**Mark Speakman**  
Minister for Heritage

**Campbell's Stores, The Rocks – Application SSD 7056**

I write to raise my concerns in relation to the proposed new structure at Campbell's Stores, The Rocks, known as Bay 12.

02 NORTH-EAST ELEVATION
SCALE 1:50

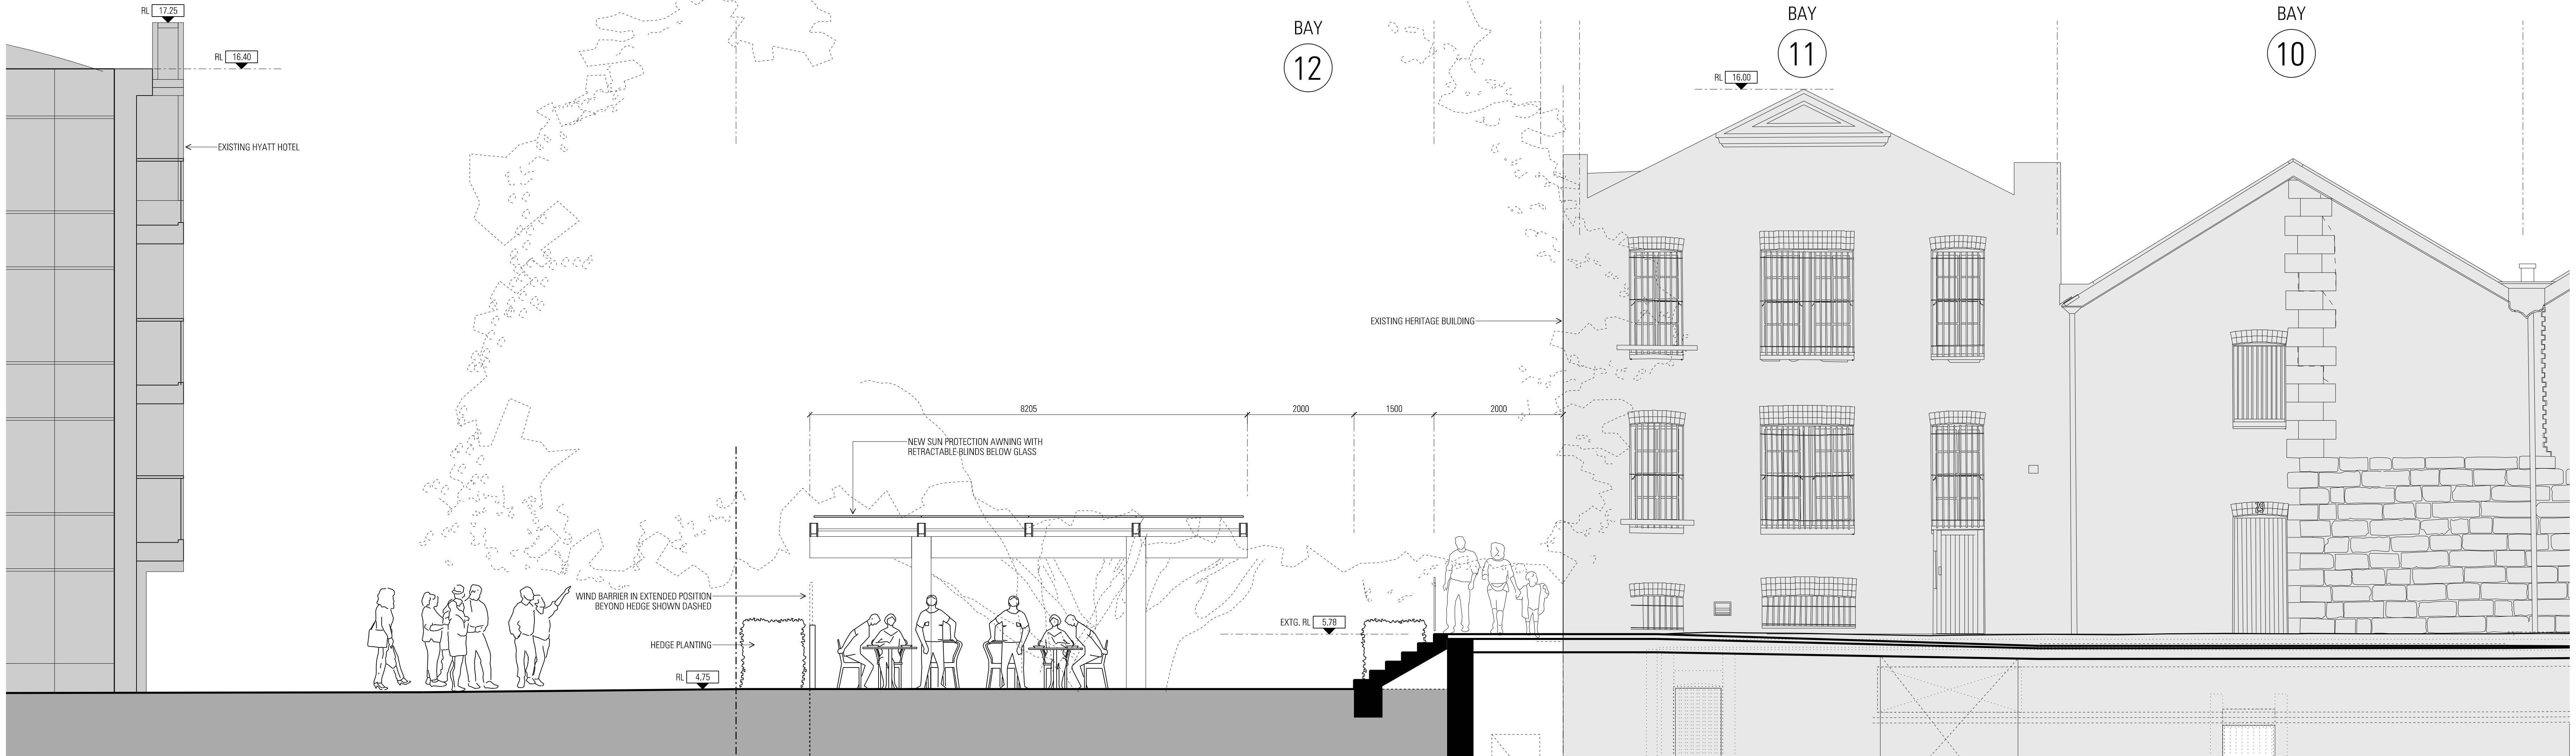
The discordant appearance of the proposal does not meet the guidance within *Design in Context* on built form. *Design in Context* states:

The argument is strengthened when considering the streetscape. The form proposed does not respond to the prevailing ground floor and roof line, which are critical to the street presence defined by load-bearing masonry walls with few, regular openings. *Design in Context* supports such an approach:

The building aligns with the street which is appropriate; however this is undermined by the treatment of the street edge, where the lack of a solid ground façade due to the raised structure undermines the streetscape.

In this case, the modern materials proposed are not proportioned or detailed in a way that is harmonious with the surrounding historic context – rather than unifying through patterns of contrast, it provides mere contrast. Materials and colours are not used in way that protects context, but instead are materials which are preferred by the architect in their other work. The use of glass blocks is without any contextual grounding, and seems more about imitating their use in other high-end retail developments. Despite a gesture to utilising warmer hues, this does not address the core issue of material choice.

*Design in Context* does provide significant freedom to utilise such detailing, and introduce new materials where appropriate in a way which contributes positively to the character of the place. The proposal here, however, does not engage with the key patterns of detailing that are characteristic of the precinct. By lacking a ground floor, the solidity and texture of masonry which give balance and frame the street are absent. The simply framed openings for doors and windows are negated by the absence of windows and doors.
